Application for Planning Permission for Works or Extension to a Dwelling

Development: Photovoltaics to roof. Insertion of rooflights and gable extension. (This application may affect the character and appearance of the Craigweil House, Aldwick Conservation Area).

Location: 62 The Drive Aldwick PO21 4DT

Project
62 The Drive
Aldwick
West Sussex
PO21 4DT
Drawing Title
Elevations as Proposed
Top - Northern (no change)
Bottom - Western

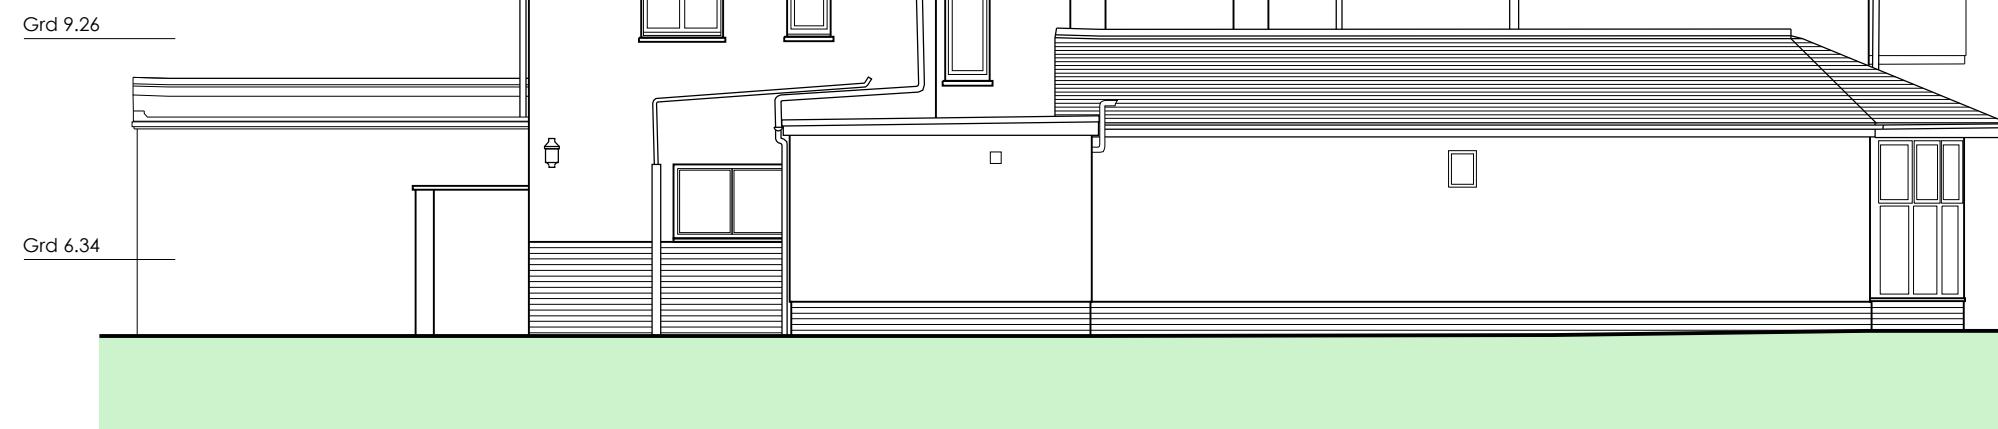
Inconsistent Plans

The existing northern elevation is inconsistent with the existing ground and first floor plans, please review and amend.
